Fwd: MMC CMP and detours- to PB Workshop on 2/27

From: **James Sweatt** <jjs@portlandmaine.gov>
Date: Fri, Feb 23, 2018 at 9:50 AM
Subject: Re: MMC CMP and detours- to PB Workshop on 2/27
To: Jean Fraser <jf@portlandmaine.gov>
Cc: "O'Brien, Stuart" <sgo@portlandmaine.gov>, "Barhydt, Barbara" <bab@portlandmaine.gov>

- a. Week one – build crane.
- b. Week 2-7 – erect precast garage.
- c. Week 8 – dismantle crane.

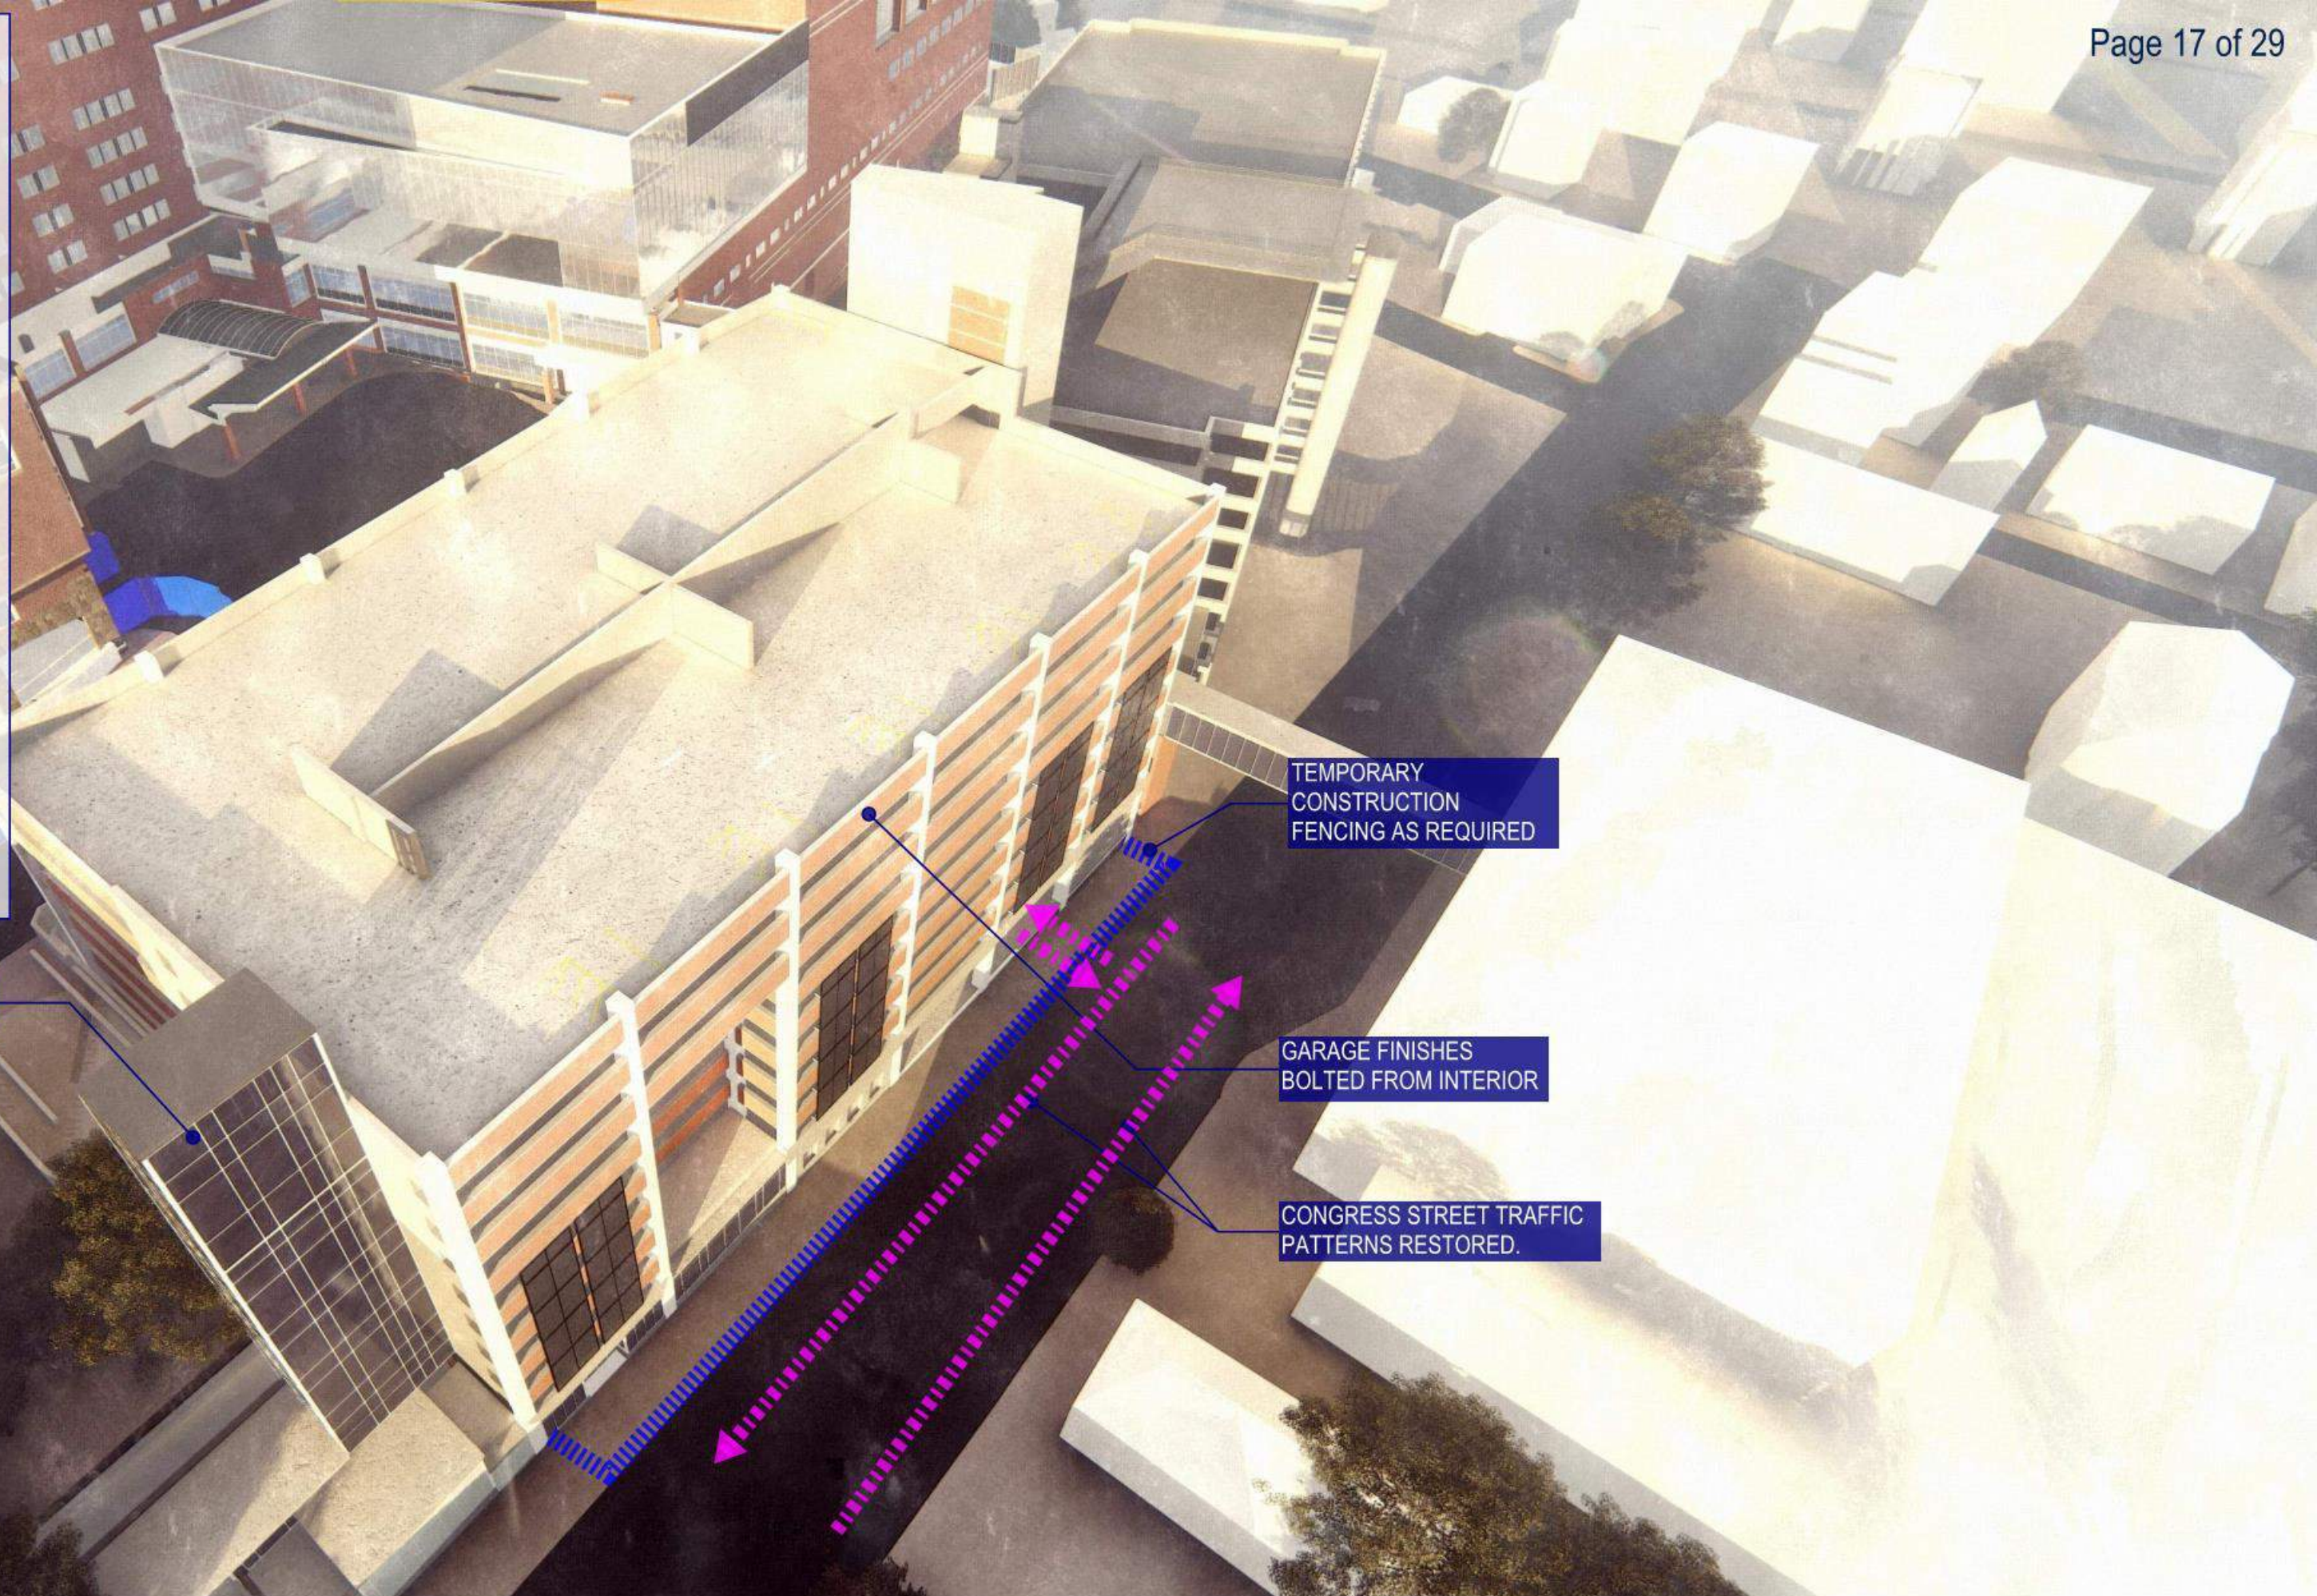
We have read, and was present during Kleinfelder's presentation of the engineering data and crane placement recommendations. It appears it will be necessary to close Congress St for the 8 week period that Turner construction has projected. It will be imperative that Turner keep to this schedule and we would recommend incentives to open Congress St sooner and substantive penalties for delays beyond 8 weeks. It will be crucial that the closure of Congress Street not extend past June 29th to avoid conflict with the highest summer traffic flow.

Turner construction must also manage the delivery of concrete casts to Congress St and steel to East Tower in a manner to avoid large vehicles with heavy loads moving during morning commuter hours (0700-1000) and afternoon hours (1500-1800). We continue to recommend the delivery and staging of large vehicles before and after normal commuting hours to reduce the impact on traffic and pedestrians.

Congress Street Detour

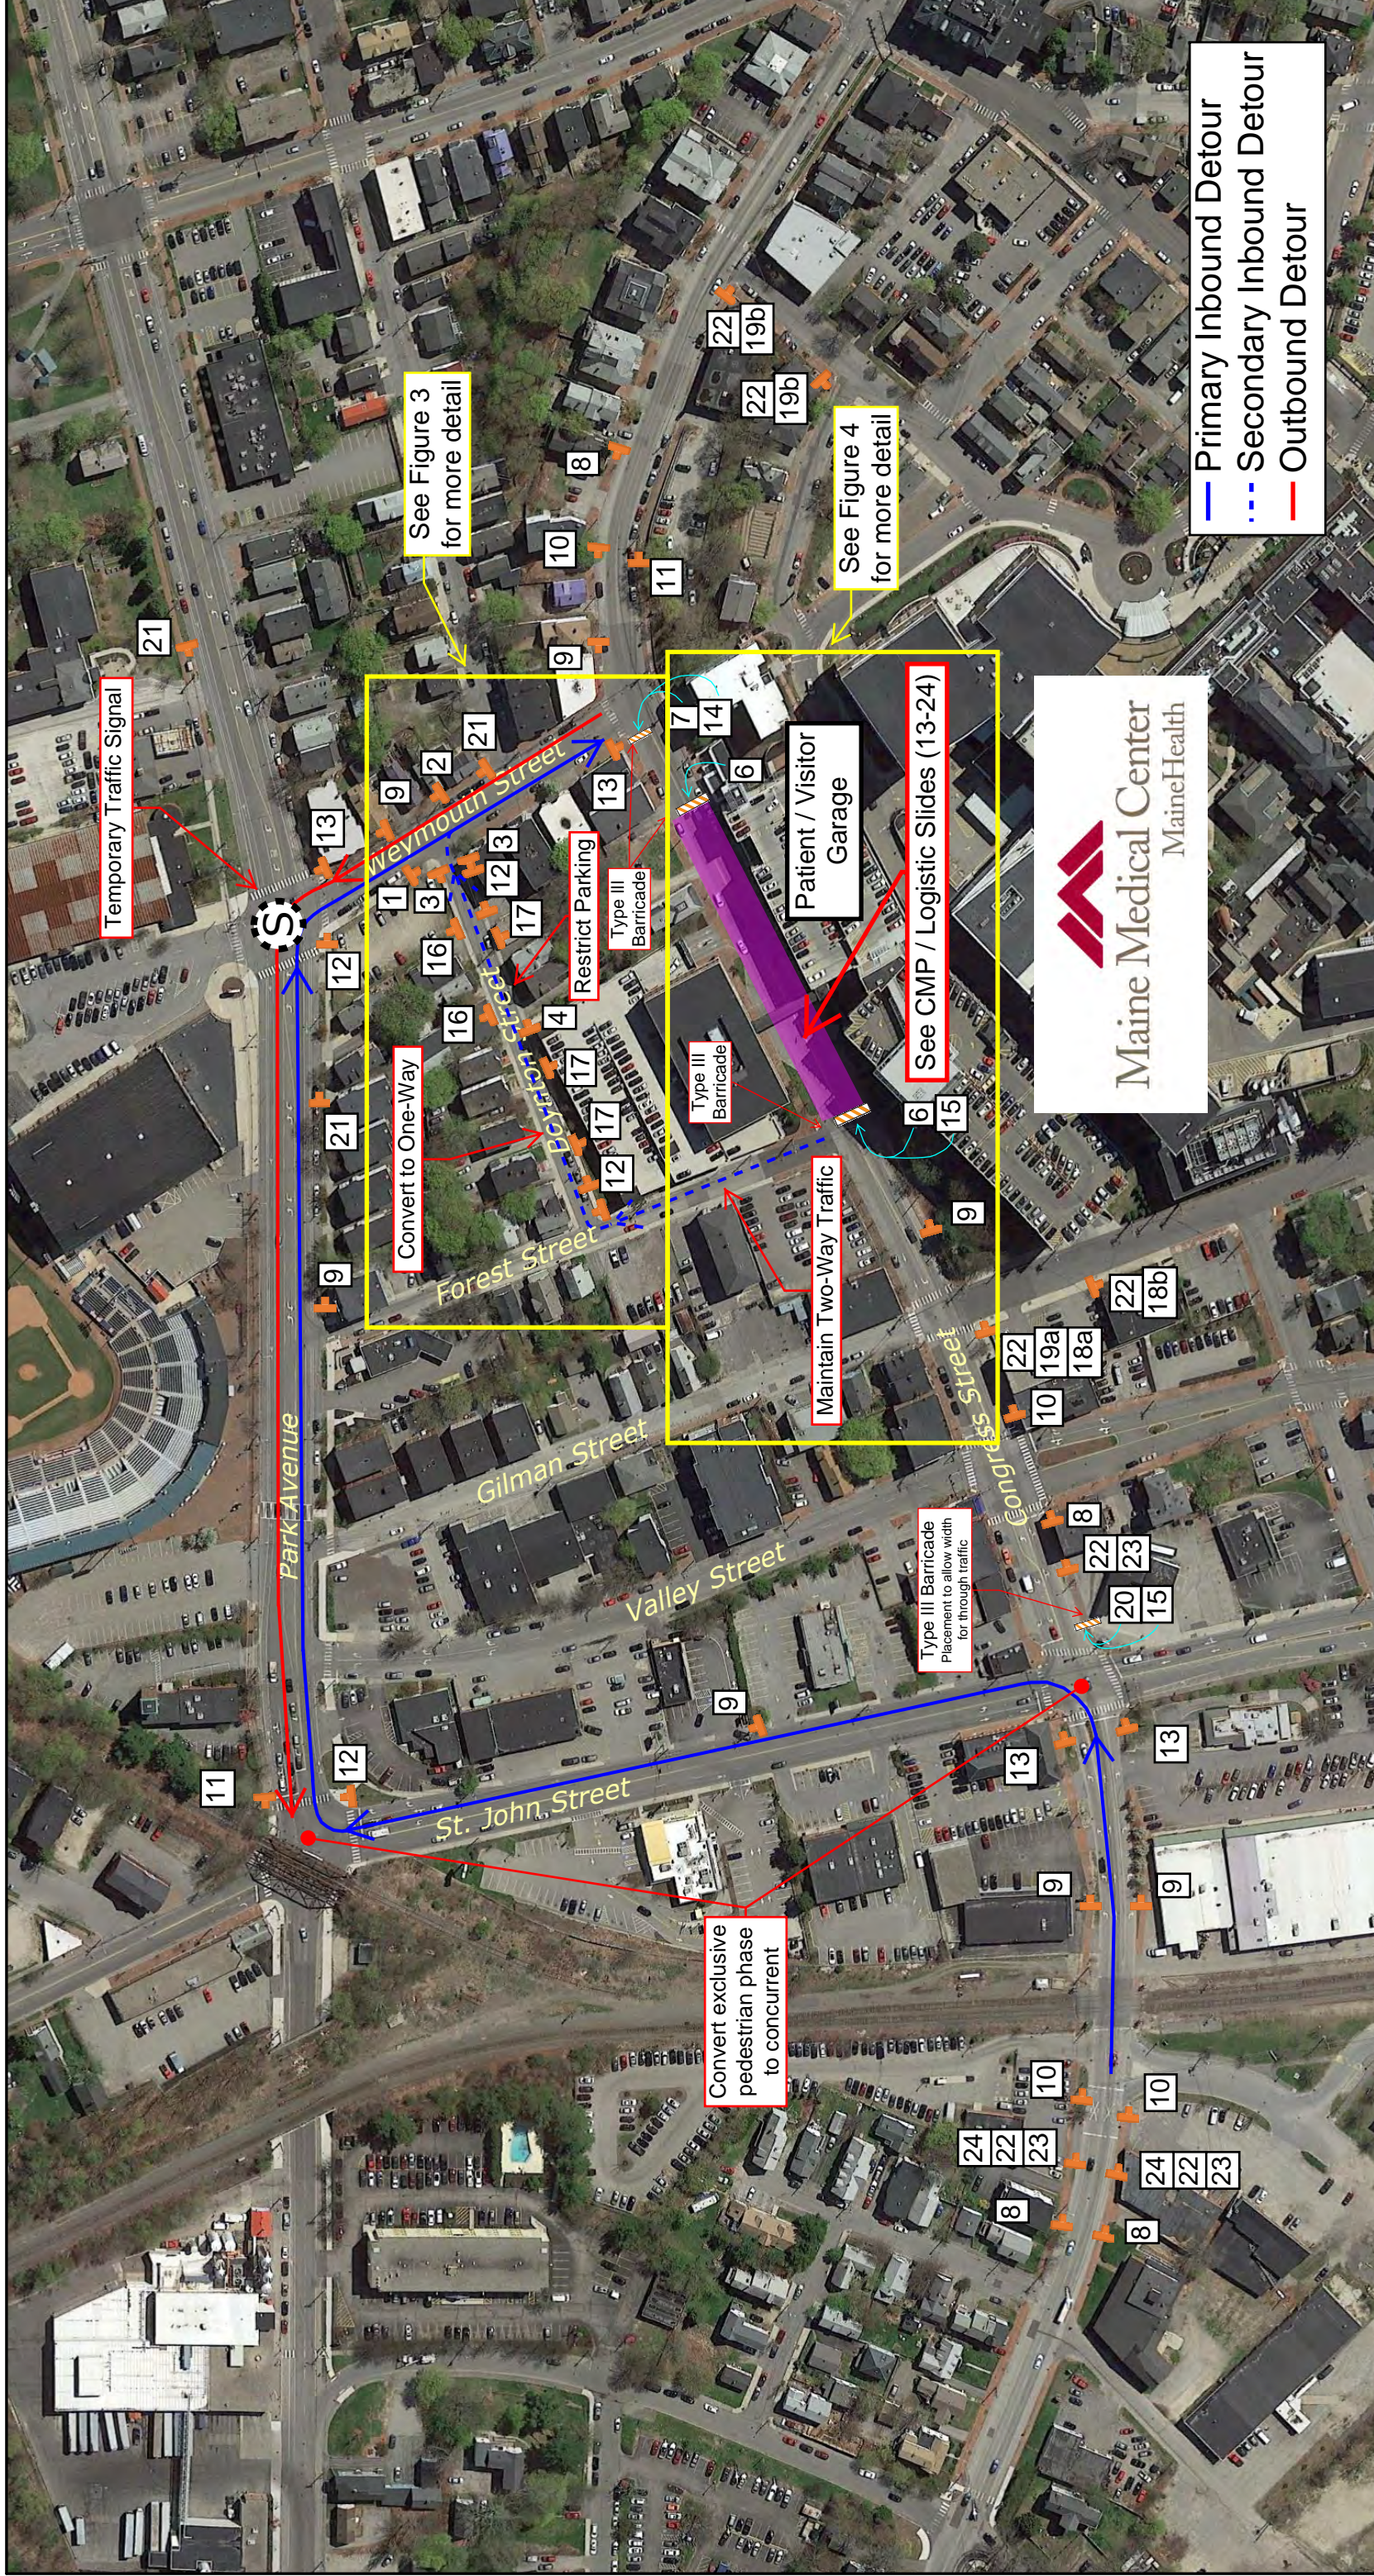
We have presented recommendations and participated in the construction detour plan. With the available details and traffic projections, the plan presented at the 2/15/18 meeting appears to be the best option during the road closure and construction of the East Tower and garage over-build. Having said that, we believe the detour has to be monitored throughout the closure to insure it meets the needs of the area. Changes may be necessary after traffic patterns develop around the detour.
